Recommendation Report for Prior Notification for Householder Extension

REF NO: FP/51/18/PDH

LOCATION: 30 Links Avenue
Felpham
PO22 7BX

PROPOSAL: Notification under permitted development rights for proposed rear single storey extension extending 6m from the original rear wall of the dwelling house, 4m high with an eaves height of 3.27m

PROPOSED GROUND FLOOR PLAN

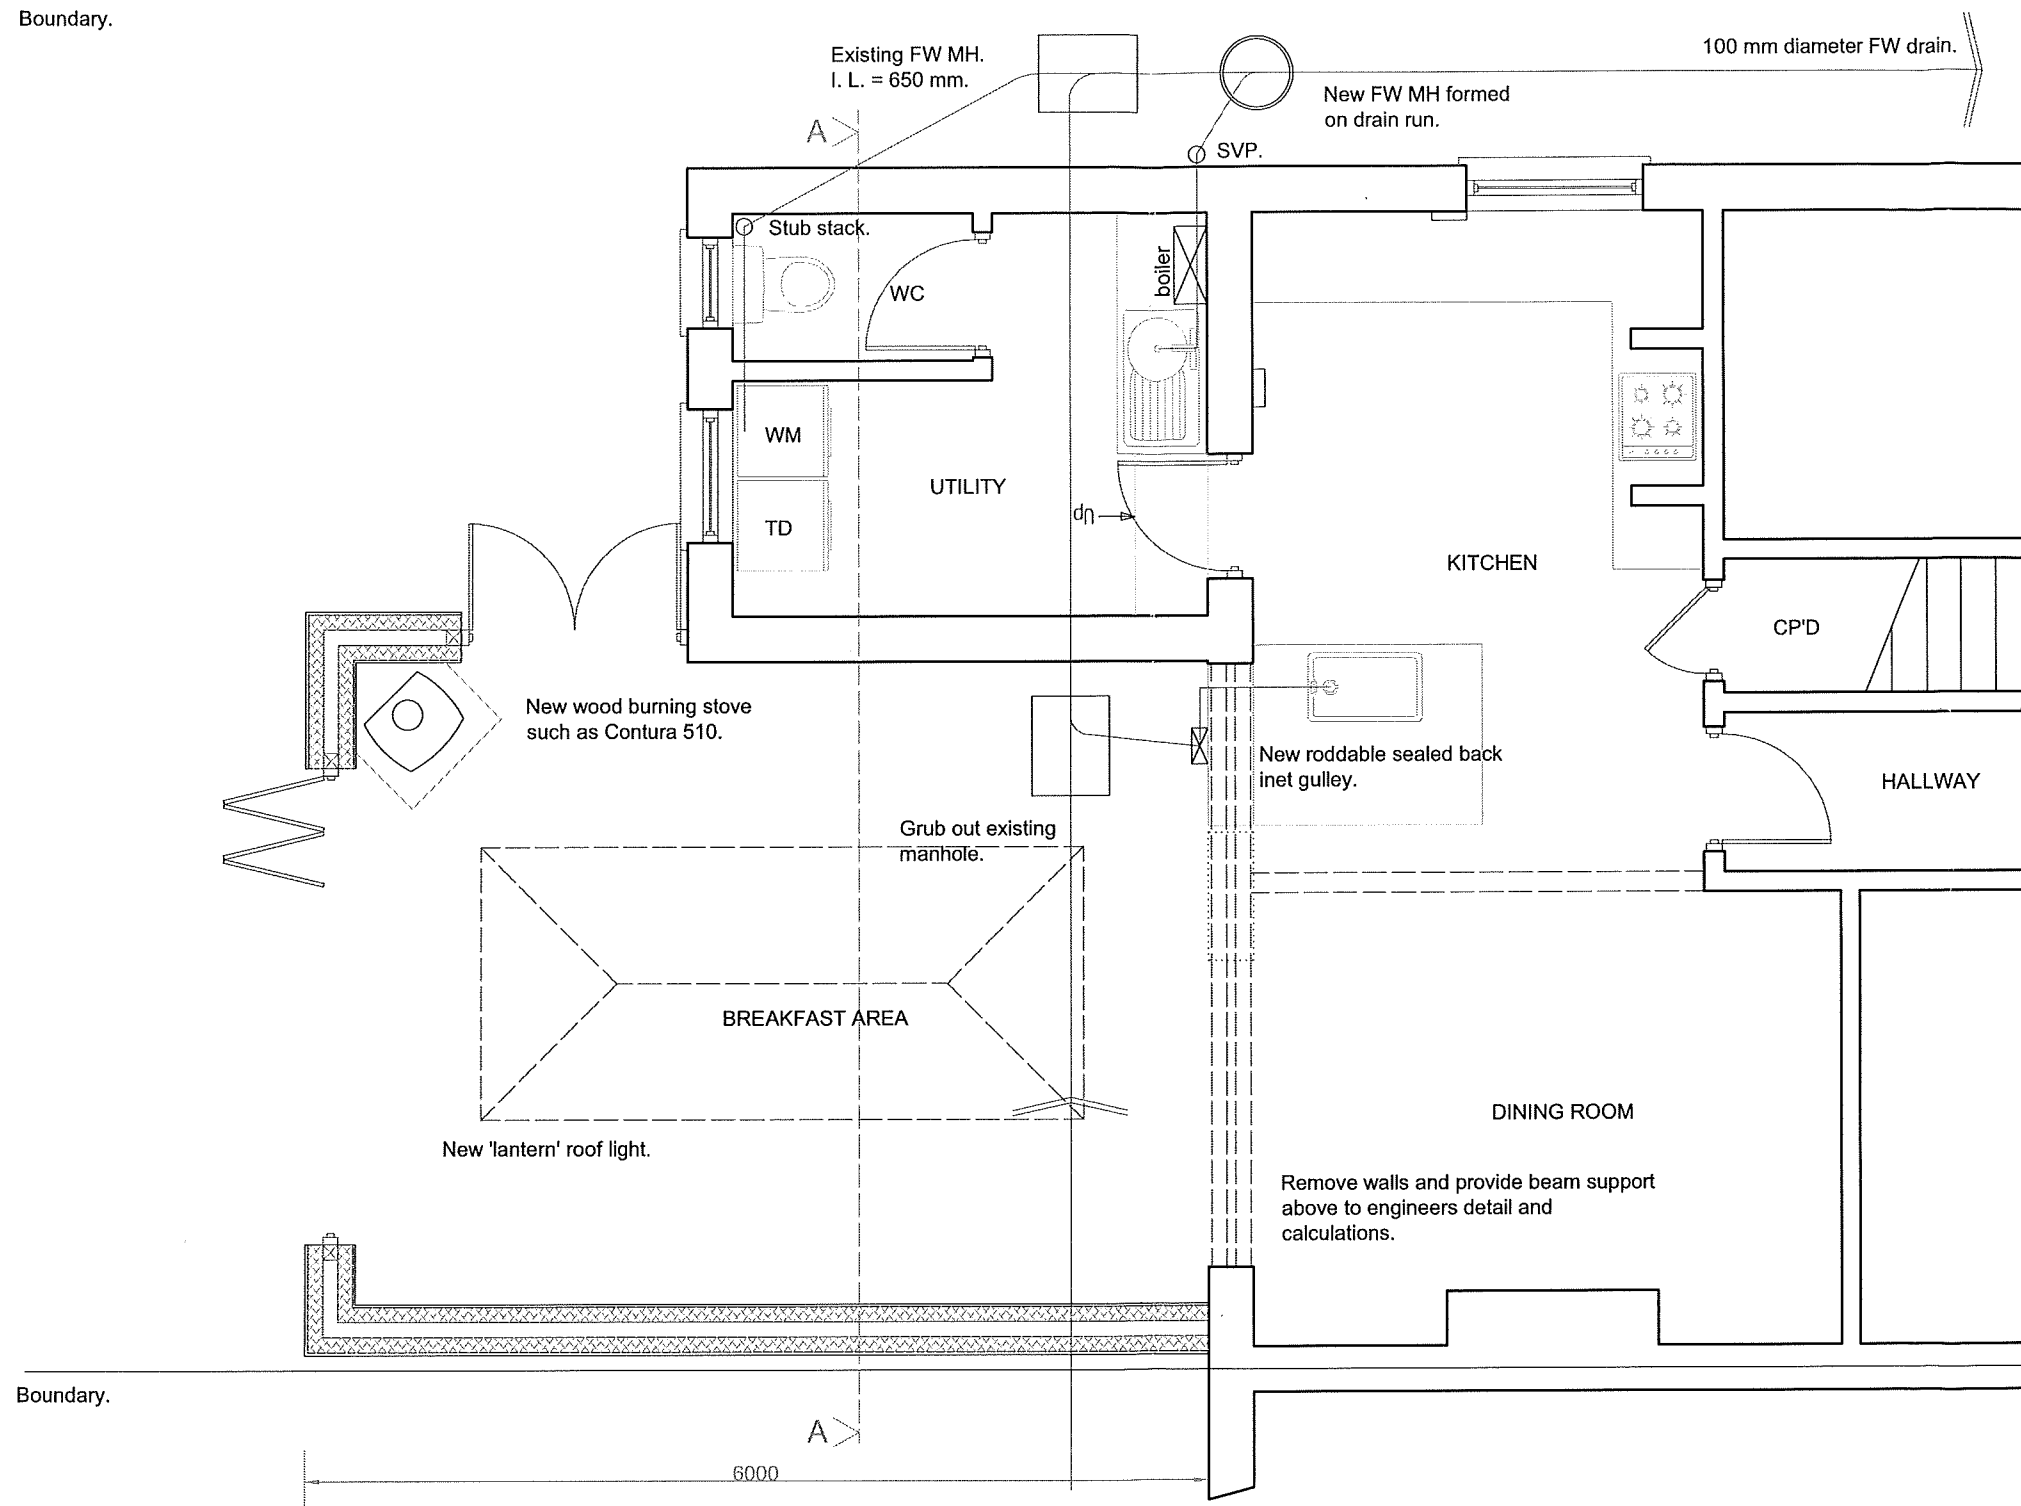
- Schedule 2, Part 1, Class A - (i) - "the enlarged part of the dwellinghouse would be within 2 metres of the boundary of the curtilage of the dwellinghouse, and the height of the eaves of the enlarged part would exceed 3 metres"

The proposed extension falls within 2m of the boundary of the curtilage of the dwellinghouse, however, it has a proposed eaves height of 3.27m.
